Ref 2022/0375 – Advertisement Consent Application

Proposal: 1 x Externally fixed illuminated fascia sign

Address: Unit R9A, The Glass Works, Barnsley, S70 1GW

SITE:	BLACK AND WHITE THE GLASSWORKS
TITLE:	PROPOSED SIGNAGE

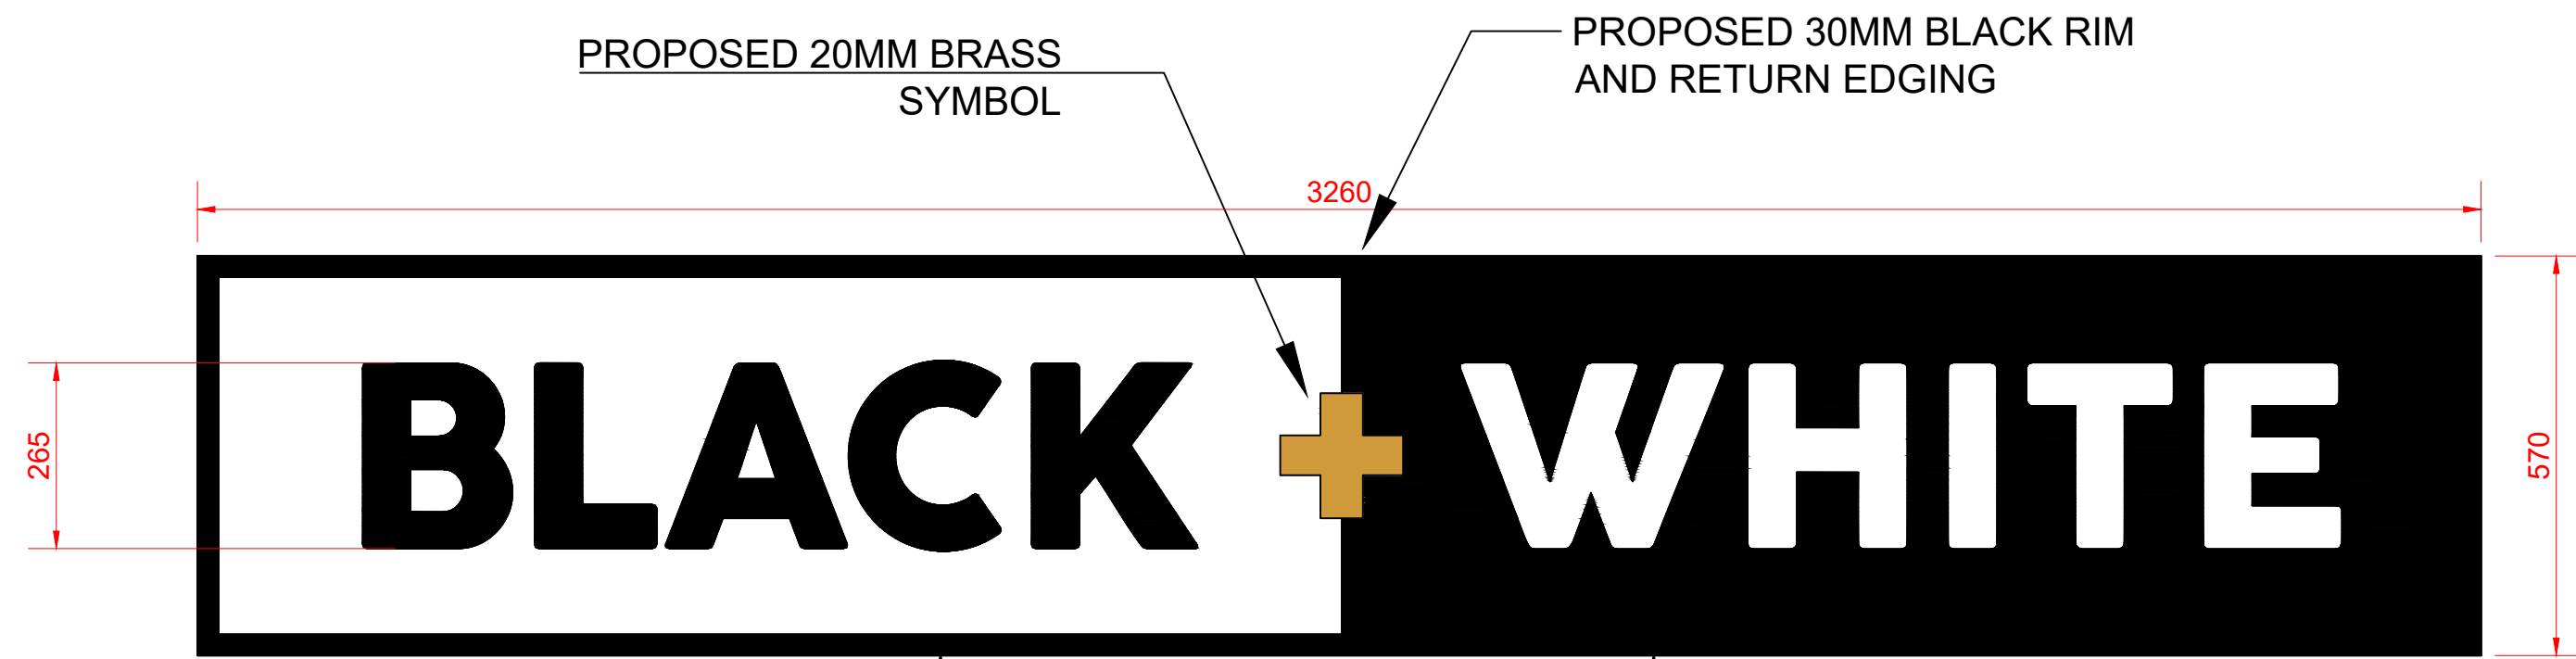
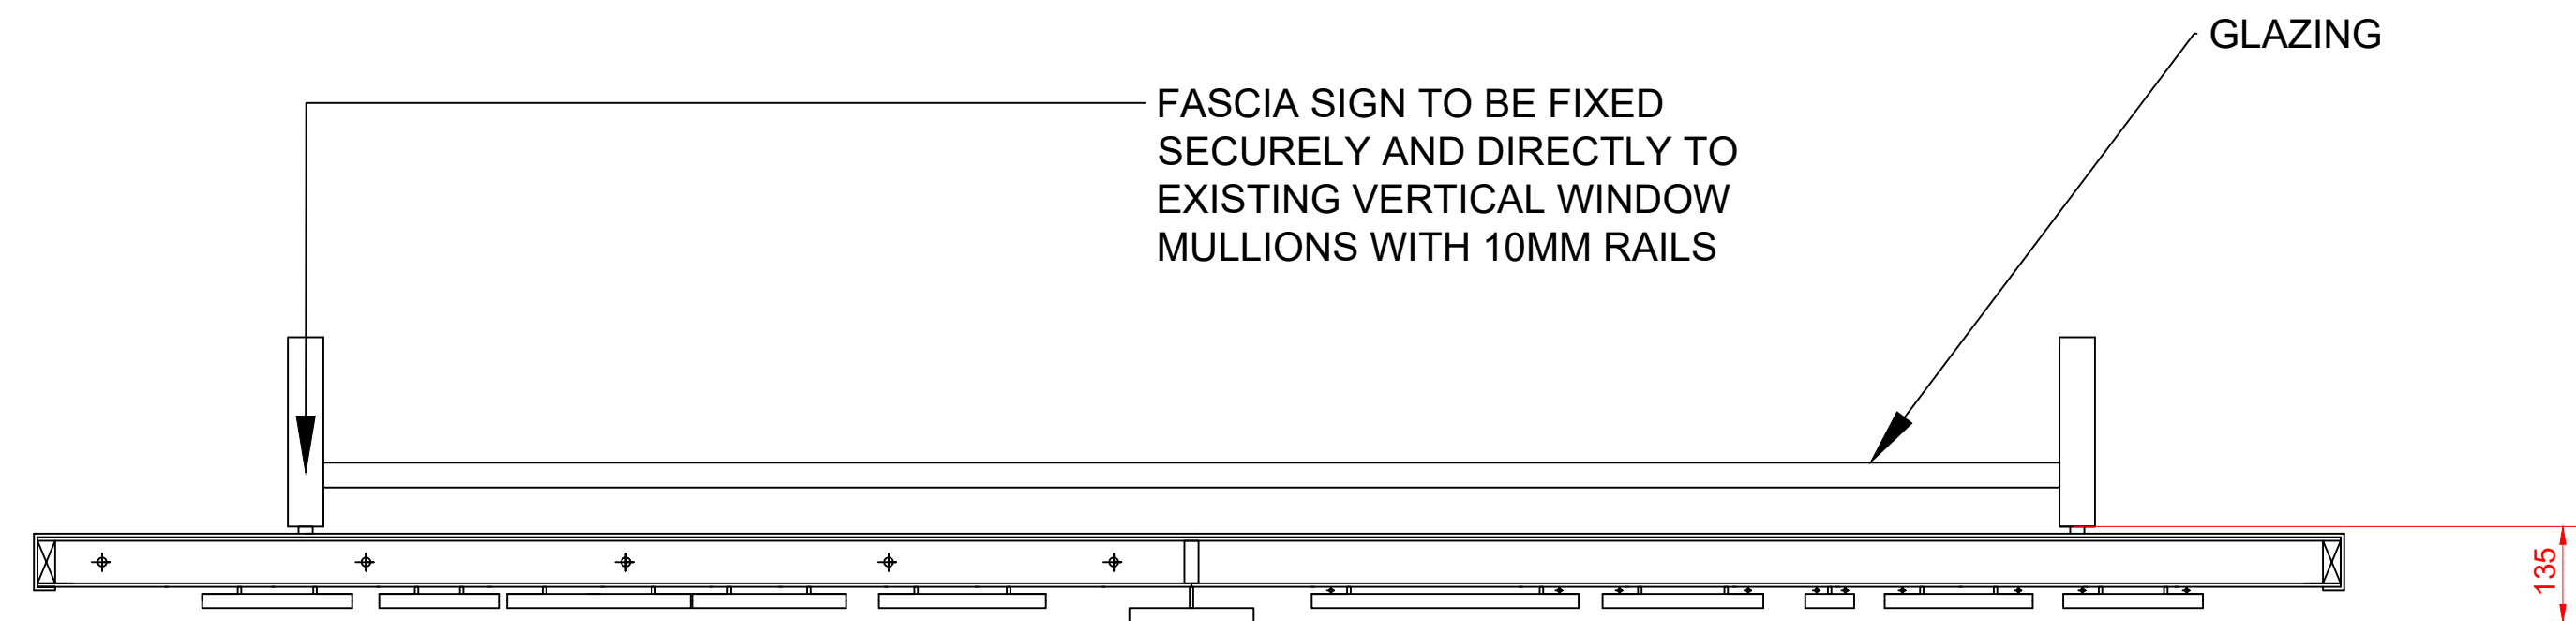
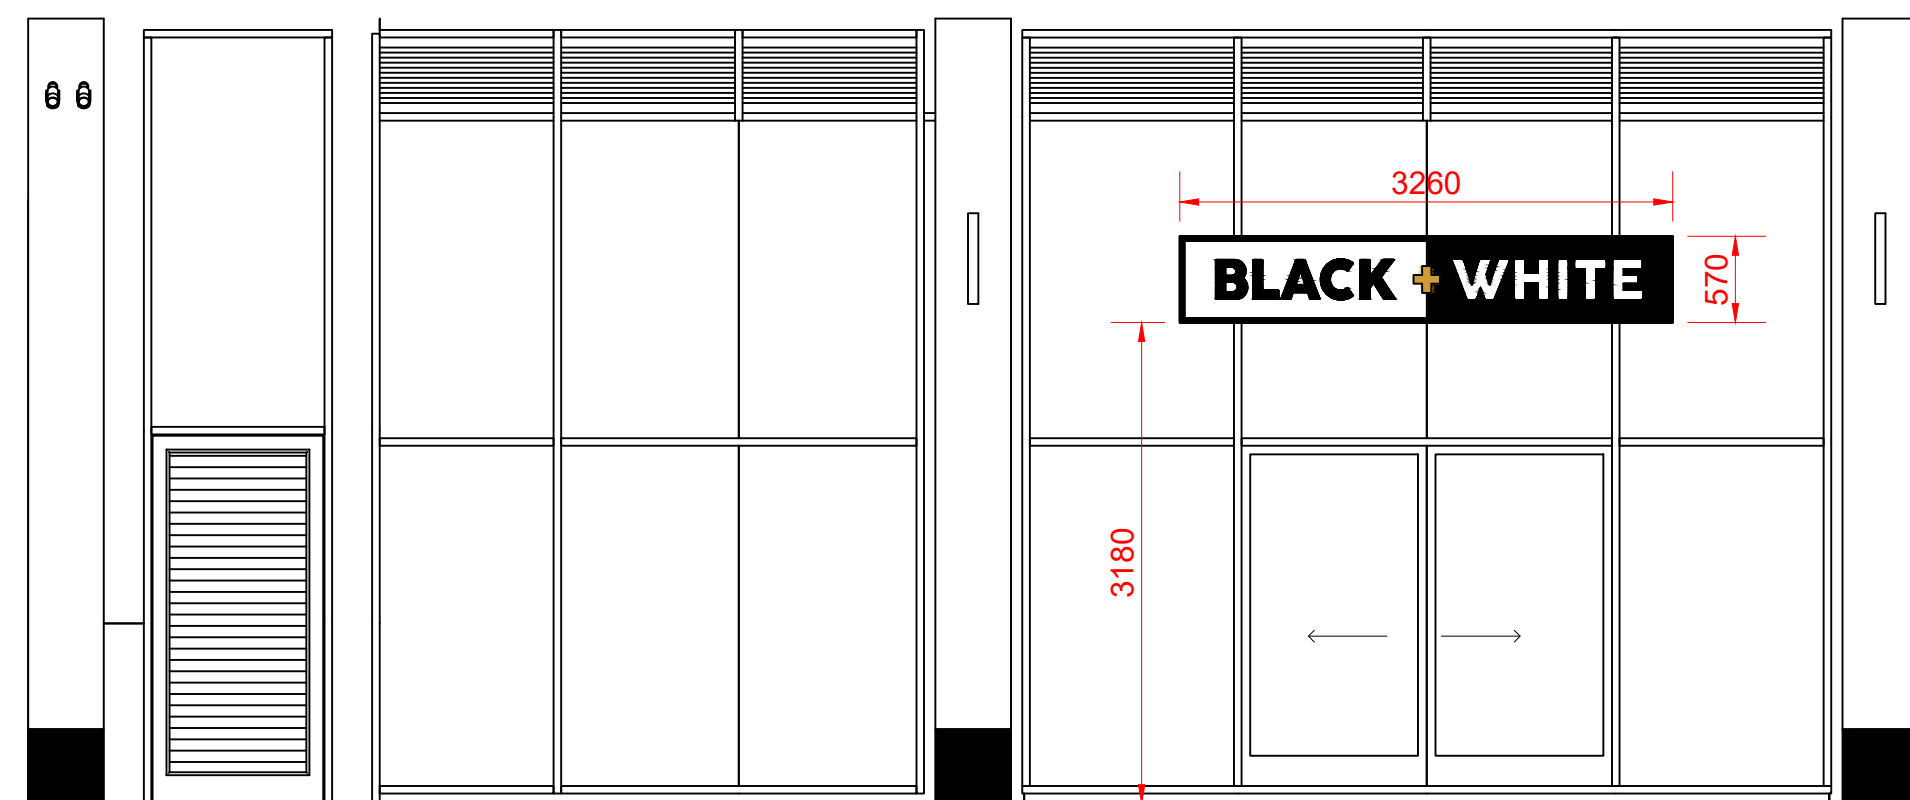
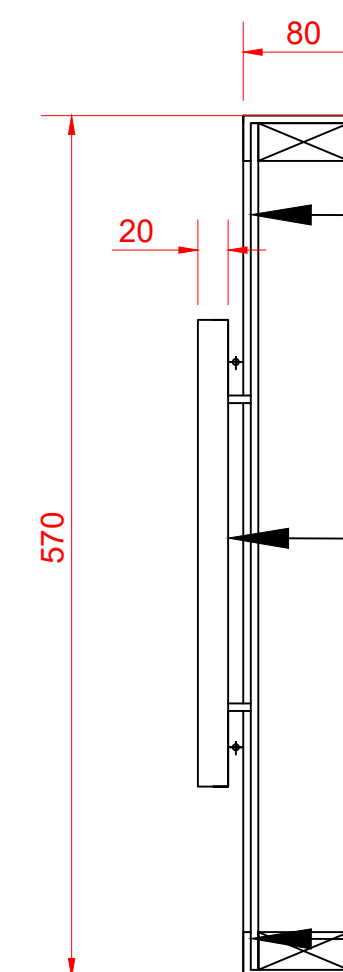
Design – Requested that the depth of the individual 3D letters and the symbol be increased to at least 20mm with no change in the gaps between the letters or symbol and the acrylic face/background. This would allow the lettering to read as 3D, which is encouraged by the shop front design guide for the Glass Works. Without this change the lettering would look relatively flat against the fascia sign/background. Also requested clarification that there are no window bed displays and that the glazing will remain clear, thereby allowing views into the main body of the shop.

Following adverse comments from both the Design Officer, the application has been amended to increase the depth of the lettering while retaining the gaps between the letters/symbol and the fascia, to ensure that the letters will read as 3D. This reflects the guidance in the Glass Works Shop Front Design Guide. It has also been clarified that the unit will have no window bed displays and all the shopfront glazing will remain clear.

The applicant seeks permission to display a single fascia sign and has amended the proposal to reflect the comments of the Conservation and Design Officers, including increasing the depth of the proposed letters and symbol and confirming that the unit will have no window bed displays and all the shopfront glazing will remain clear.
